**Re: Oakdale South Industrial Estate (SSD 6917)
Erskine Park, Penrith LGA
Applicant's Response to Submissions**

Eastern Boundary Landscape Section

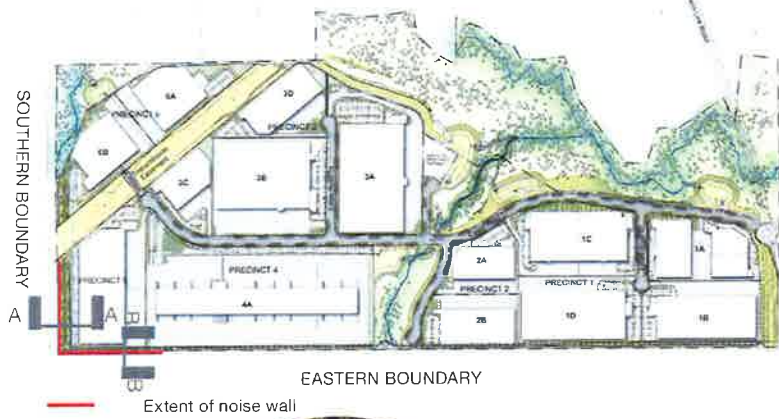
It is difficult to confirm from the VIA and the landscape drawings whether the landscaping treatment will extend along the entire Eastern boundary, or whether it is simply limited to the area directly around the noise wall. The long-term impacts would definitely be improved if the landscaping treatment of 10m in width, as illustrated in Section C-C of Appendix D to the RTS, were extended along the entire length of the Eastern boundary. That would ensure that the unsightly buildings were blocked from view of all properties on Greenway Place, as well as the proposed rezoned RU4 land on the Jacfin site. It would also help to break up the view of acres and acres of rooftops for those residents with a higher elevation, as well as mitigating the risk of rooftop glare and night lighting. The Department should not approve this application without this landscaping along the whole length of the boundary. It is unreasonable that Goodman are relying on screening from another development which has not yet commenced construction, has not even received final approval and its timing for completion is unknown. Ultimately, view corridors between the Jacfin buildings, as well as roads on the Jacfin site, would still allow us to view the Oakdale buildings in between. OSE need to provide their own mitigation controls at their own cost.
